Our ref: HA/2022/124004/04-L01
Your ref: M/16/22/PL

Date: 15 November 2022

FURTHER MODELLING INFORMATION: RE-CONSULTATION - LAYING OUT OF AN 18 HOLE 72 PAR GOLF COURSE, A 9 HOLE GOLF COURSE, PRACTICE GREENS AND A DRIVING RANGE INCLUDING A BUGGY COMPOUND; THE FORMATION OF A NEW ACCESS ONTO THE A259; CONSTRUCTION OF A CLUB HOUSE WITH ASSOCIATED GOLF CLUB FACILITIES; THE CONSTRUCTION OF A MAINTENANCE BUILDING AND EXTERNAL AREA OF HARDSTANDING; THE LAYING OF PARKING, NEW ROADS AND PATHS; NEW LANDSCAPE PLANTING; SURFACE WATER DRAINAGE BASINS AND WATER STORAGE RESEVOIRS; AND OTHER EARTH WORKS AND INFRASTRUCTURE. THIS APPLICATION ALSO LIES WITHIN THE PARISHES OF CLIMPING AND YAPTON, IS A DEPARTURE FROM THE DEVELOPMENT PLAN AND AFFECTS A PUBLIC RIGHT OF WAY. THIS APPLICATION IS SUBJECT TO AN ENVIRONMENTAL STATEMENT. LAND SOUTH OF GREVATTS LANE/A259 CLIMPING.

HYDRAULIC MODEL RESULTS

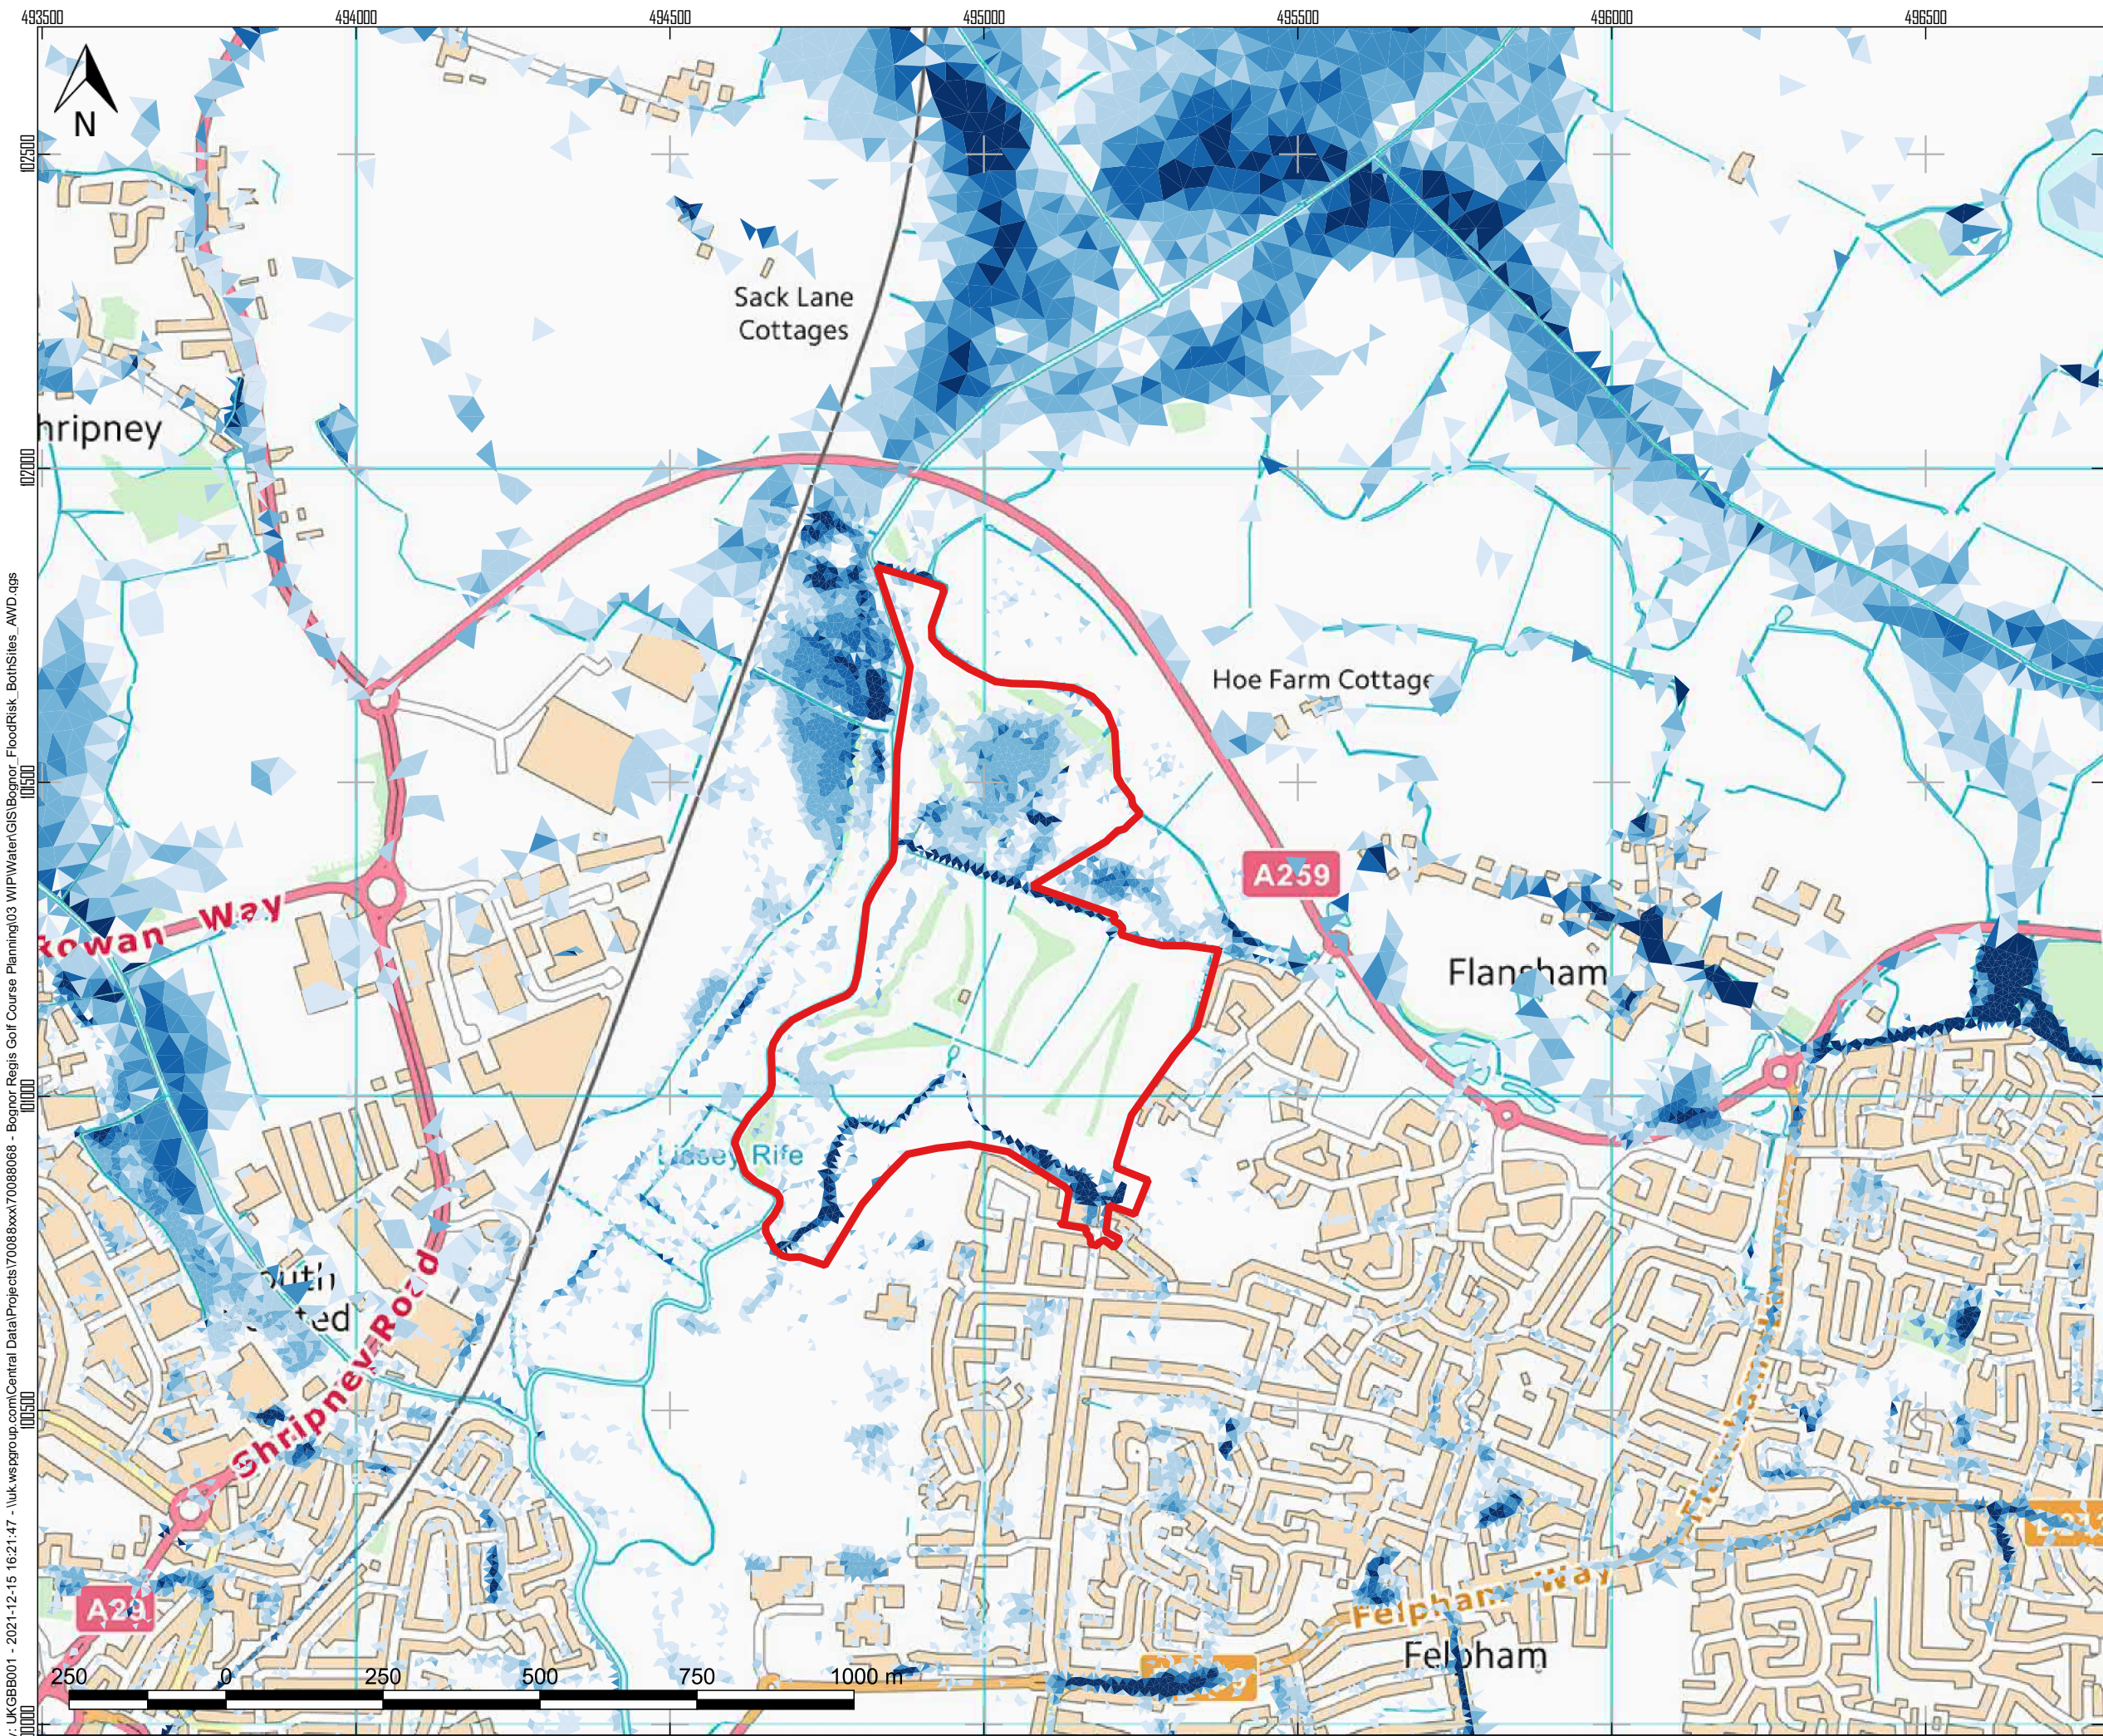
Drawing number 70088086-FLD-IMP-024 Rev A shows changes to modelled flood levels/depths as a result of the proposed development. This drawing shows that the proposed development is likely to increase flood depths on Grevatt's Lane (A259)

- The proposed development will impede flood flow and/or reduce storage capacity thereby increasing the risk of flooding to Grevatt's Lane (A259)

To overcome our objection, the applicant should submit evidence to demonstrate that the proposal will not pose an increased risk to the A259 as highlighted above.
